8. **Project # 1004644**
06DRB-01189 Minor-SiteDev Plan
Subd/EPC

CONSENSUS PLANNING INC agent(s) for THE TRAILS LLC request(s) the above action(s) for all or a portion of, THE TRAILS, UNIT 2, SANTA FE 3, (to be known as **THE TRAILS, UNIT 9A**) zoned R-D, located on WOODMONT AVE NW, between RAINBOW BLVD NW and UNIVERSE BLVD NW containing approximately 20 acre(s). [Deferred from 8/23/06 & 9/13/06 & 9/27/06 & 10/4/06] (C-9) **DEFERRED AT THE AGENT'S REQUEST TO 10/25/06.**

**CITY OF ALBUQUERQUE
PLANNING DEPARTMENT
September 27, 2006
DRB Comments**

RE: The Trails, Unit 9A/sps

Site Plan for RD
The Trails
Unit 9A

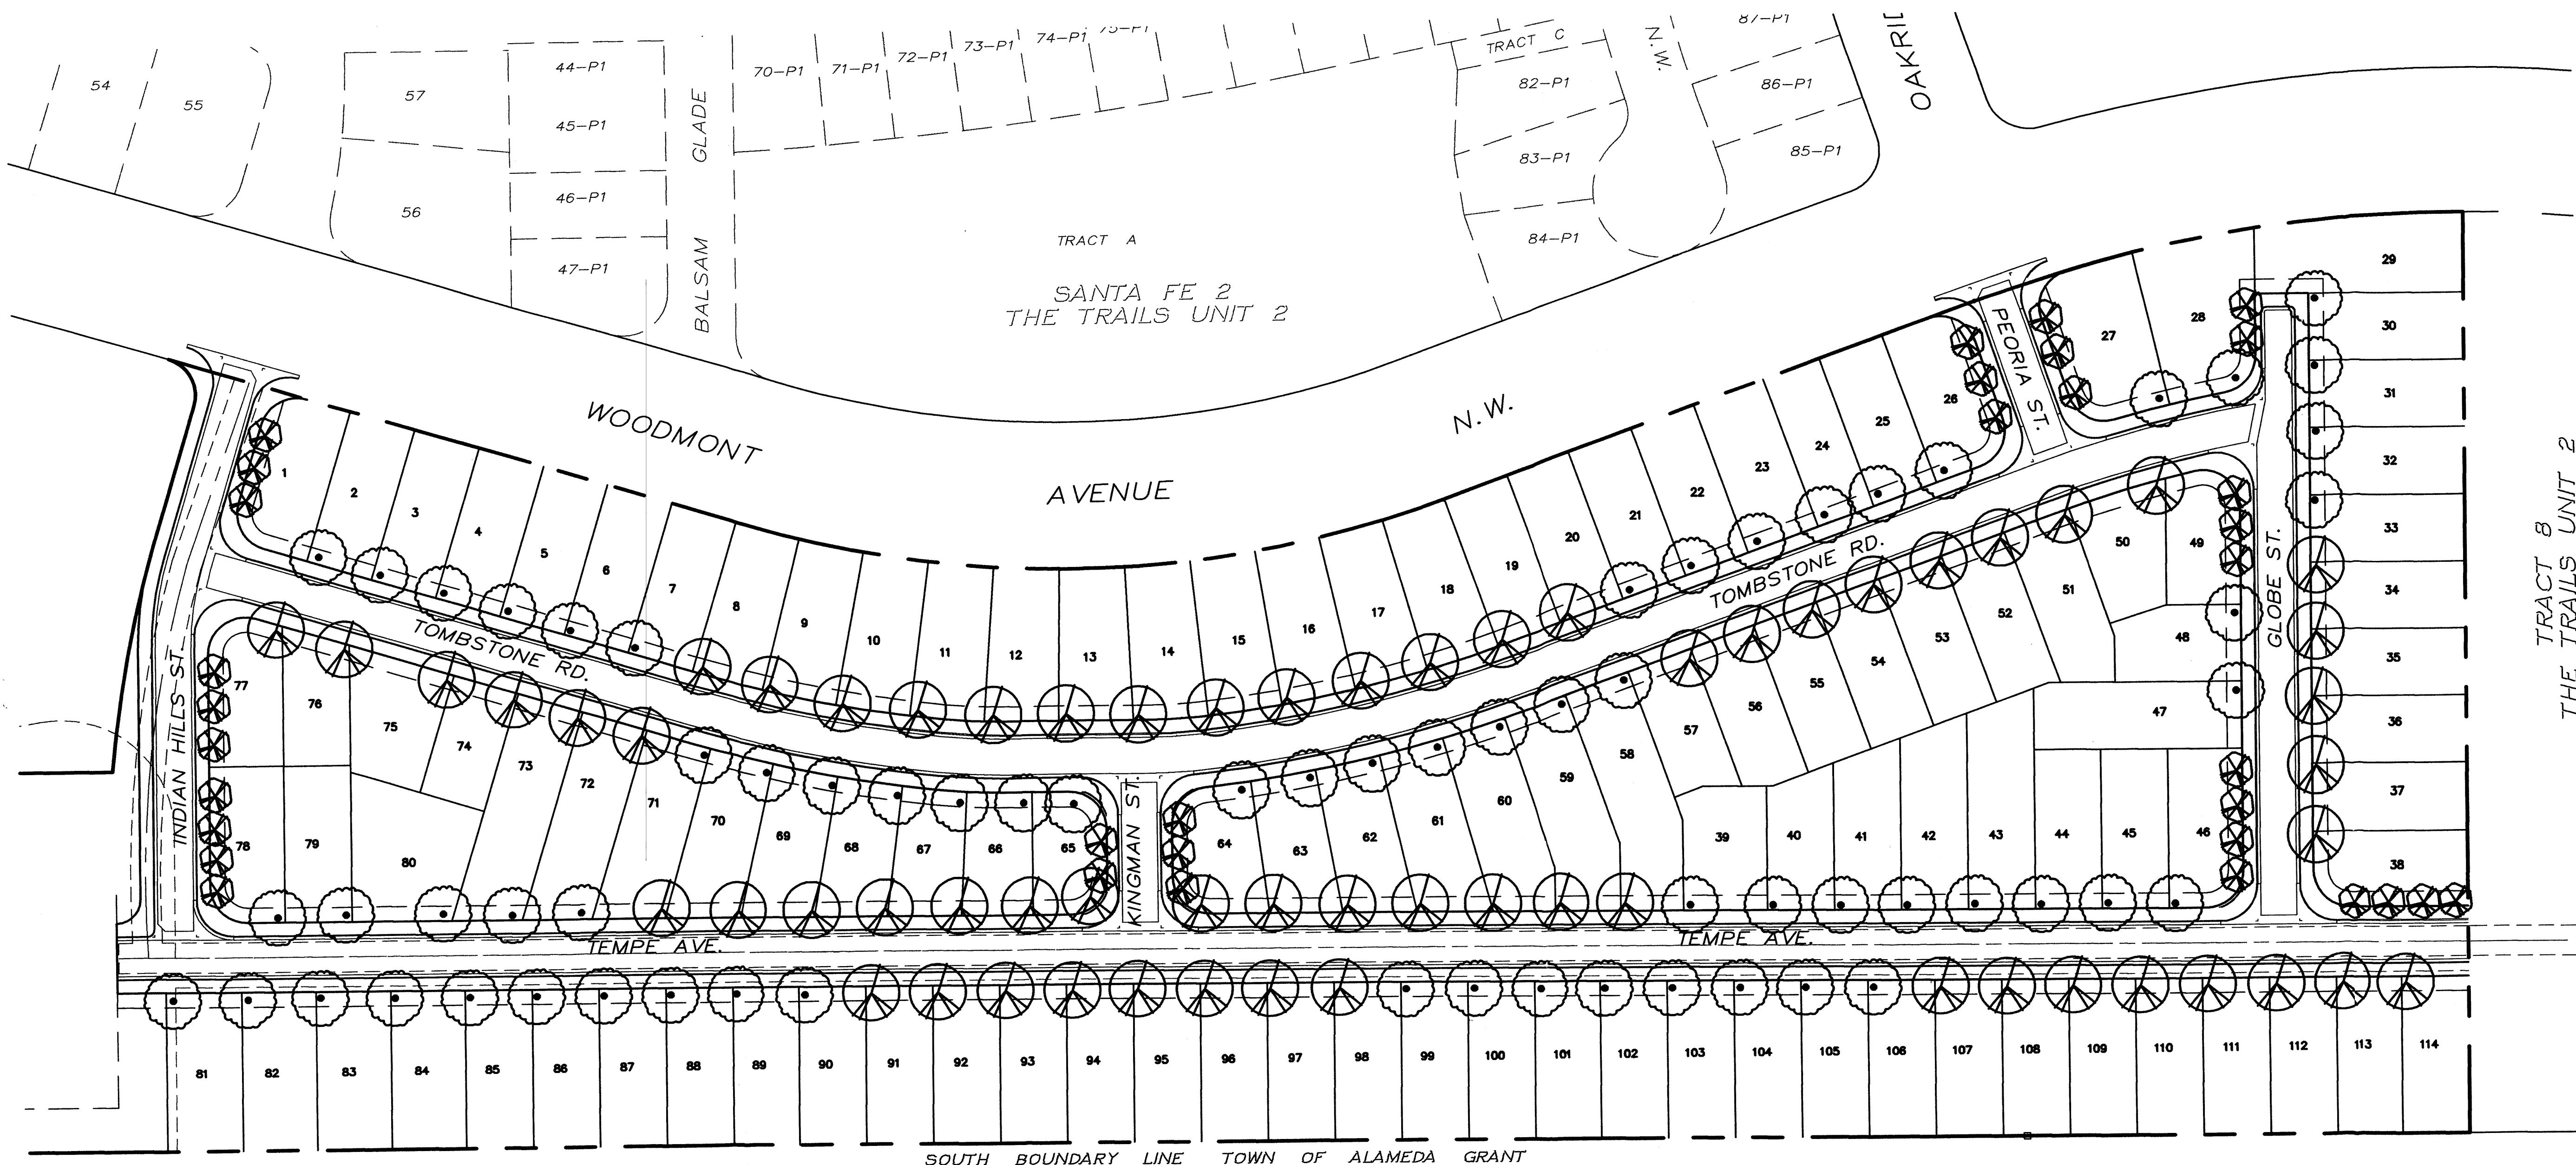
The signature block is incorrect. This is not an EPC approved site plan.

The title of the site plan should read "Site Plan for Subdivision".

Conceptual Landscape Plan The Trails Unit 9

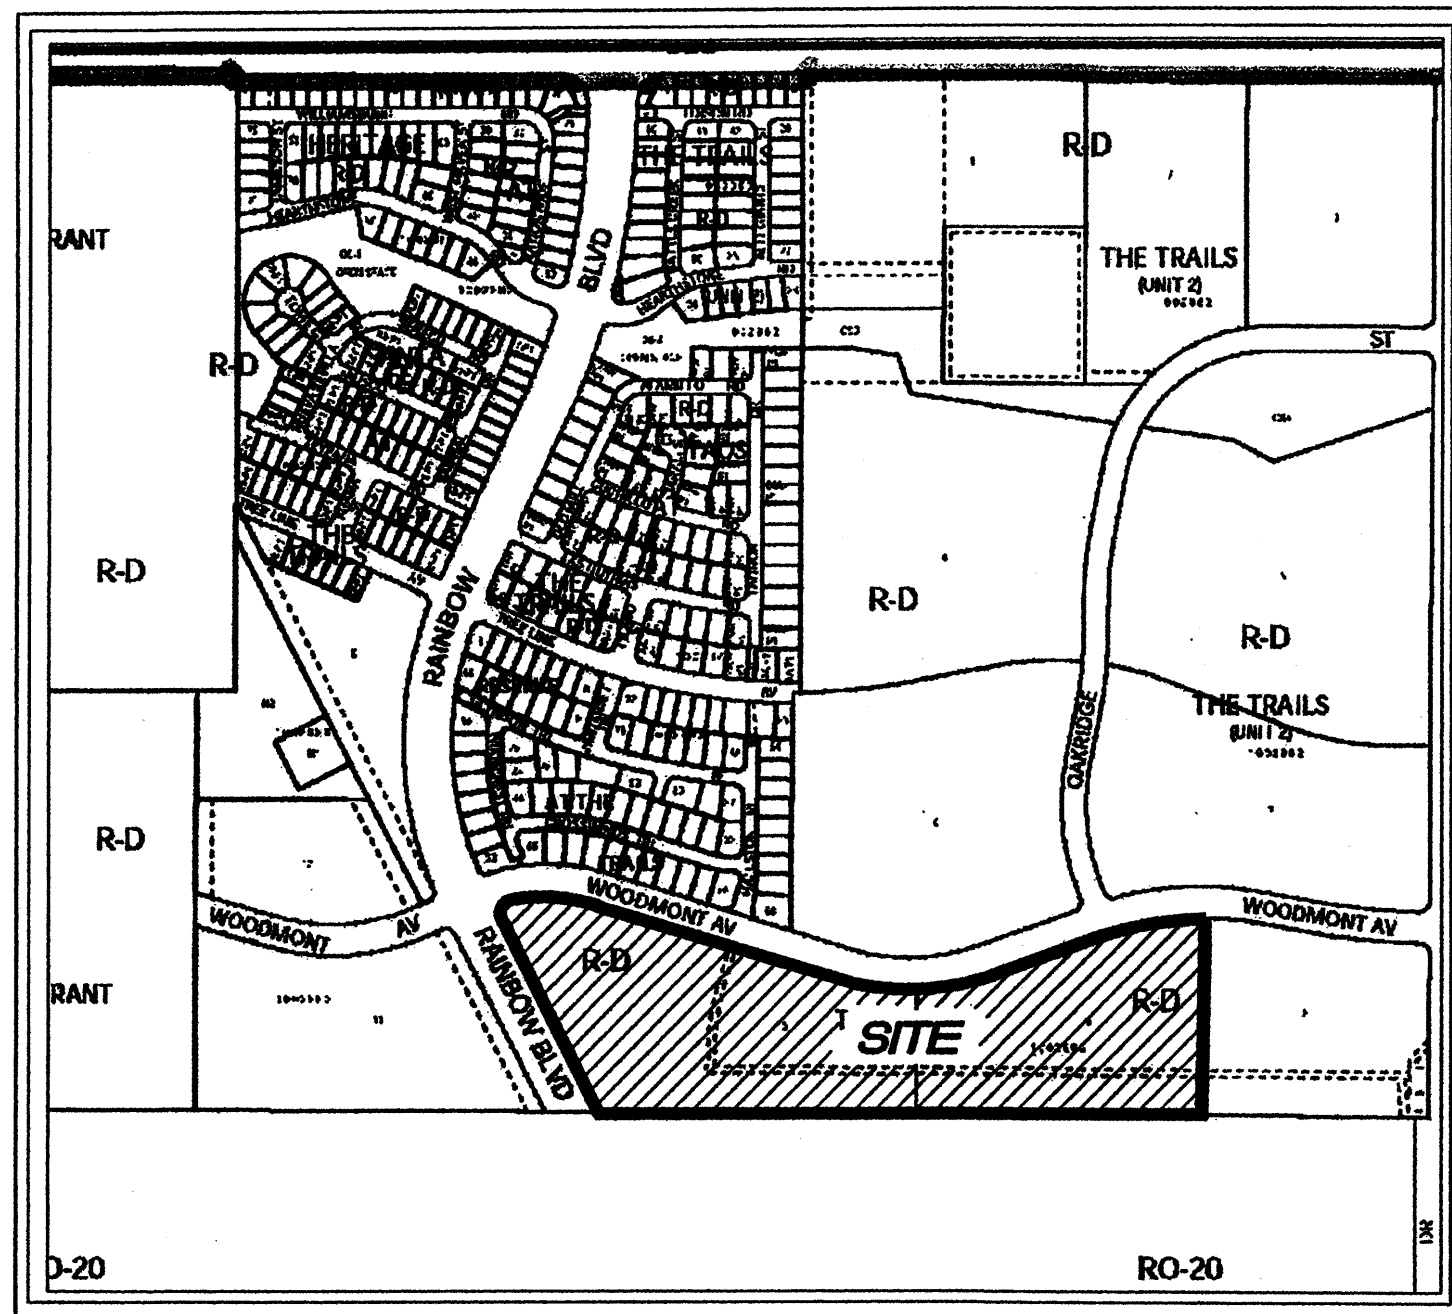
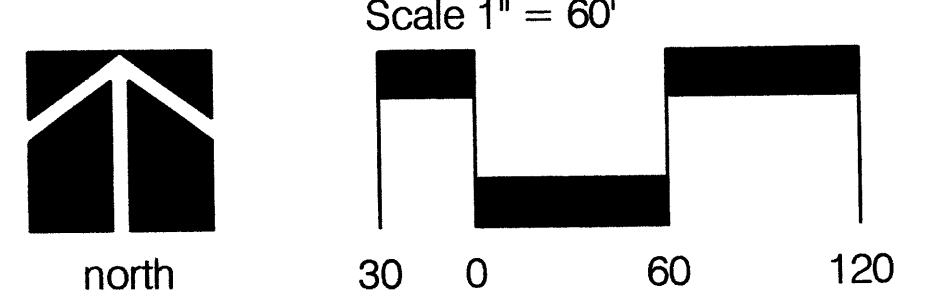
Each plant on the Landscape Plan should have the water usage listed. There are several trees listed that are higher water usage. Please substitute lower usage trees in respect for our arid climate and limited water supply.

The minimum depth of mulch should be 3".
